Application No: EP/53/22/HH
Site Address: 38 Hillview Crescent East Preston BN16 1RQ
Description of works: Hip to gable loft conversion with rear dormer.

Thank you for your internet representation made on 15th June 2022 which has been recorded as an objection with the comments as follows:

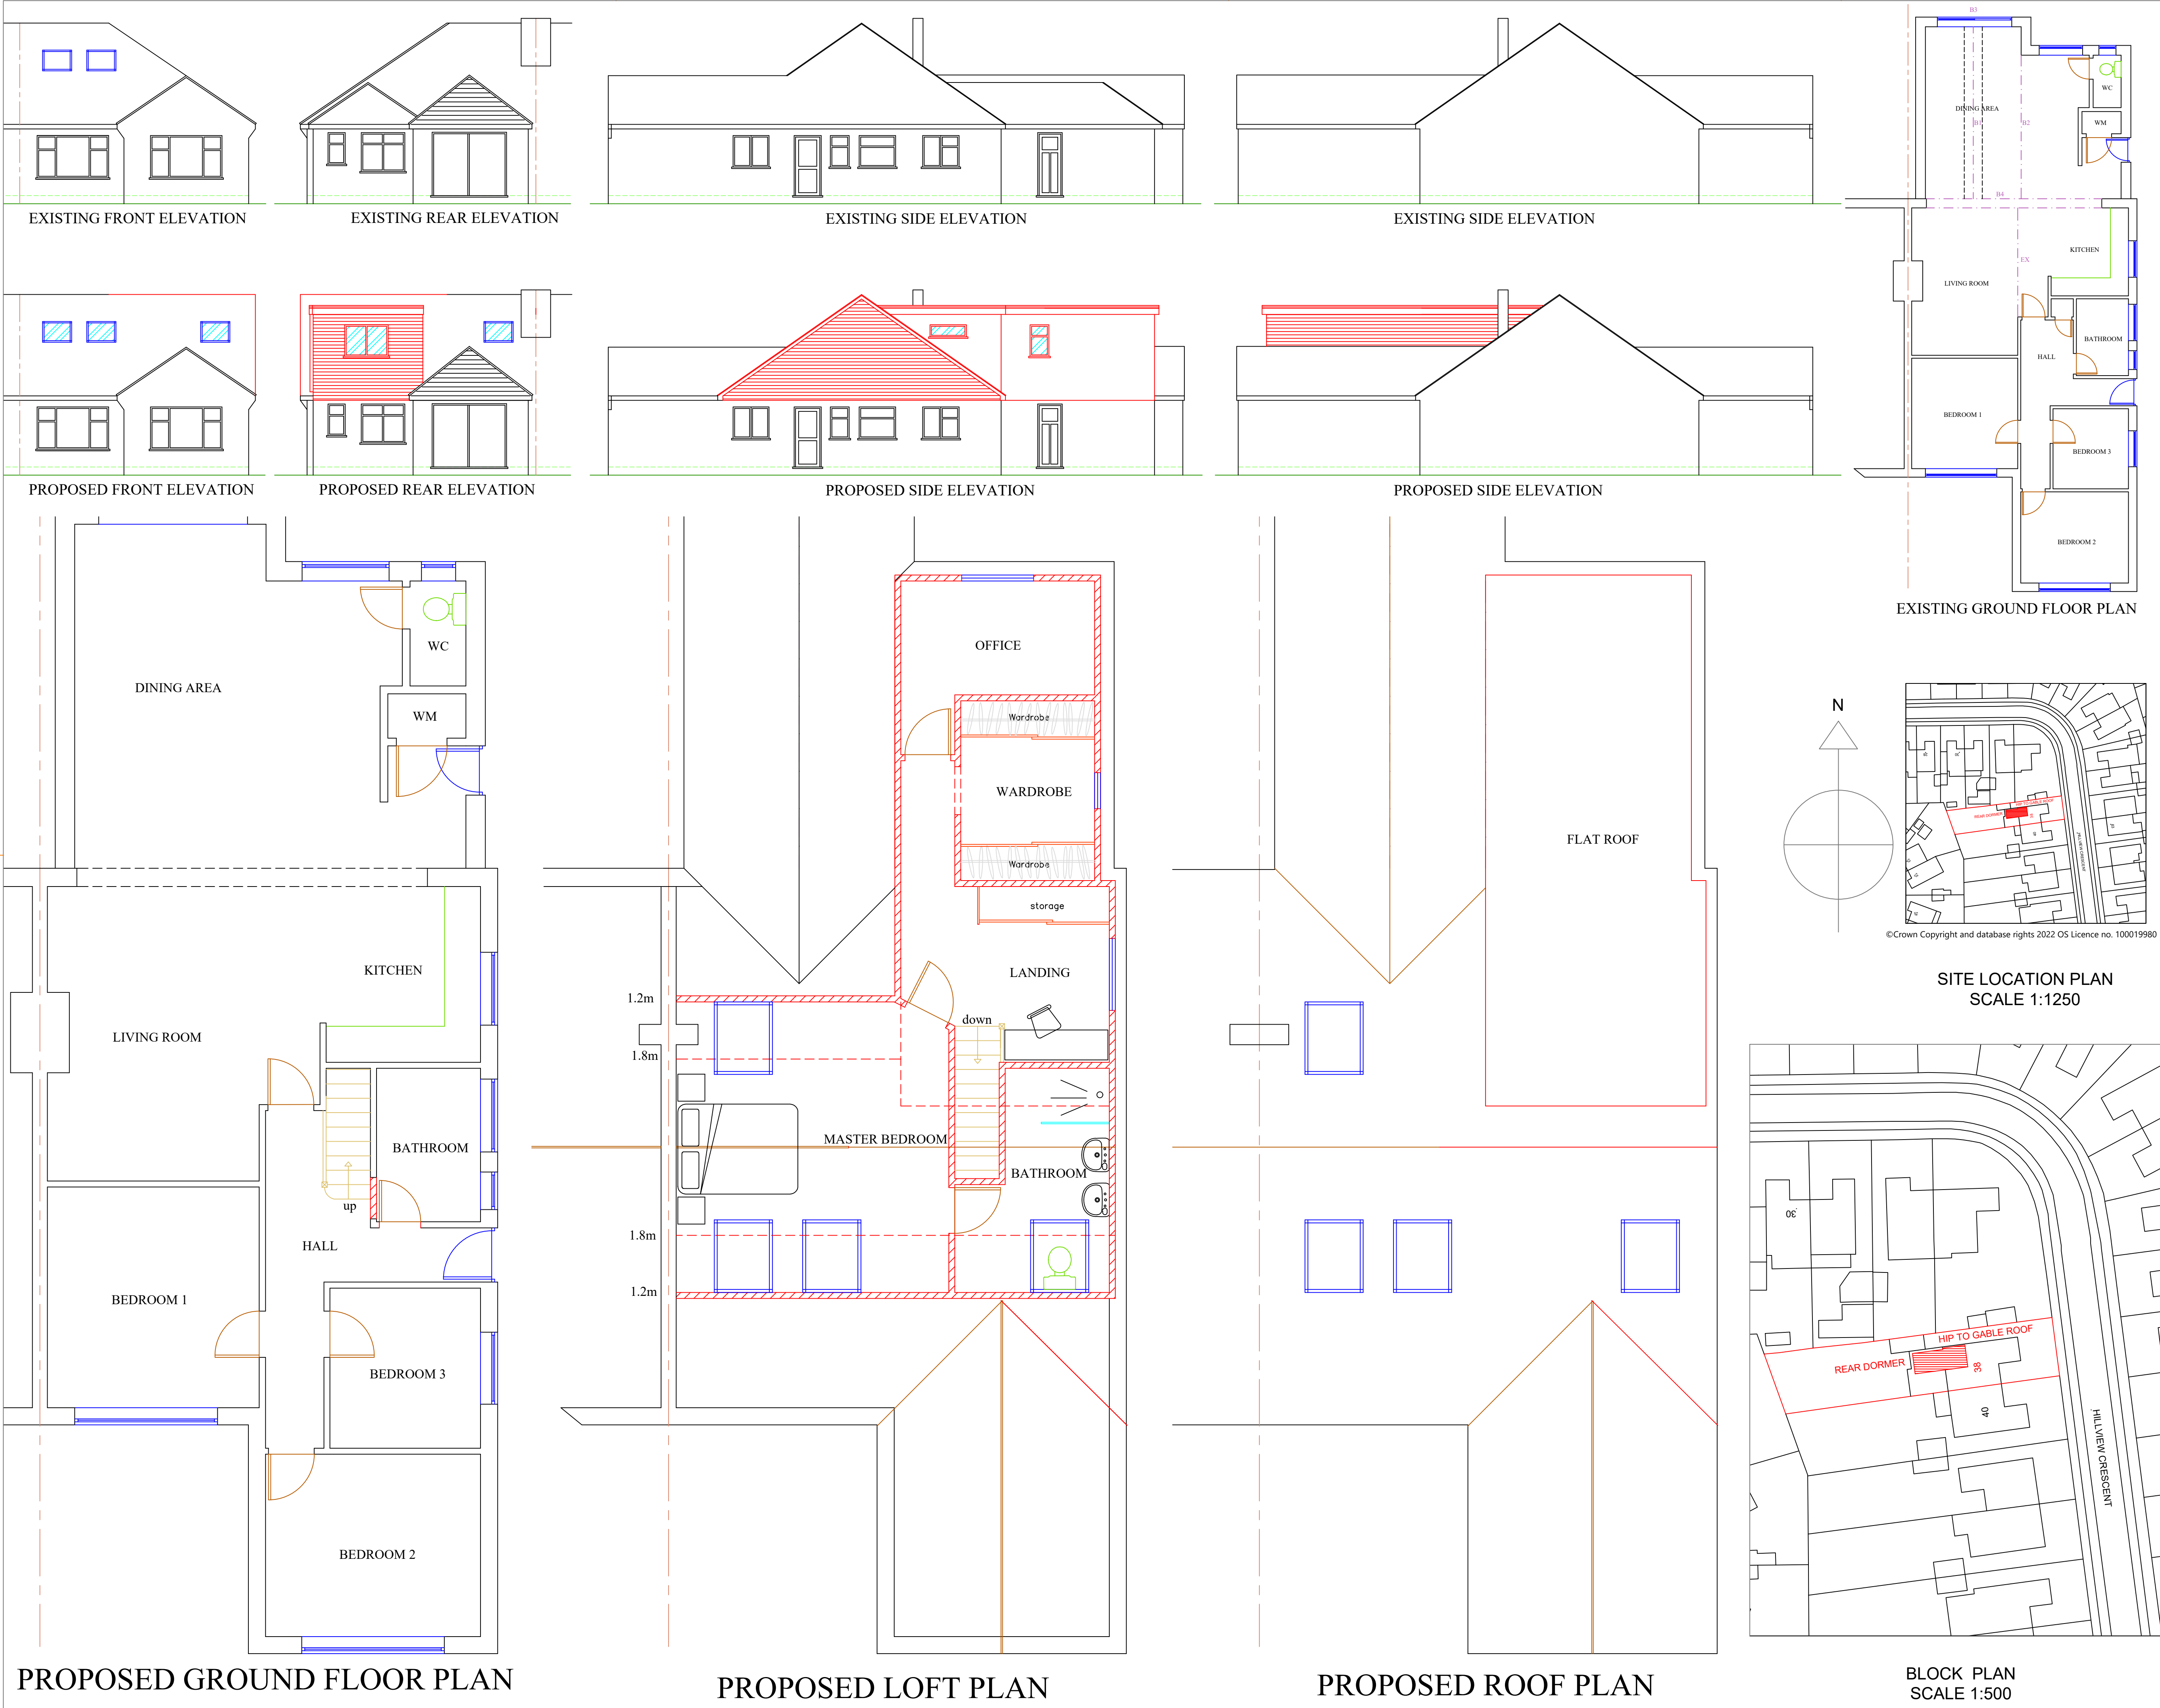
The development property is half of a pair of semi-detached bungalows. The proposed development will unbalance the pair. This conflicts with section 4.16 of the made East Preston Neighbourhood Plan which states an "enlarged house should not be unbalanced".

The proposed development will be out-of-keeping with the neighbourhood and will change the streetscene, conflicting with section 4.18 of the made East Preston Neighbourhood Plan.

The proposal to change the hipped roof on the northern elevation to a gable end is contrary to policy 4.27 of the made East Preston Neighbourhood Plan which states "A hipped roof should only be changed to a gable at the rear".

The proposed rear dormer could be considered overly long and out-of-keeping with the host property. It could also lead to a loss of privacy for the occupants of properties immediately to the north of the development site.
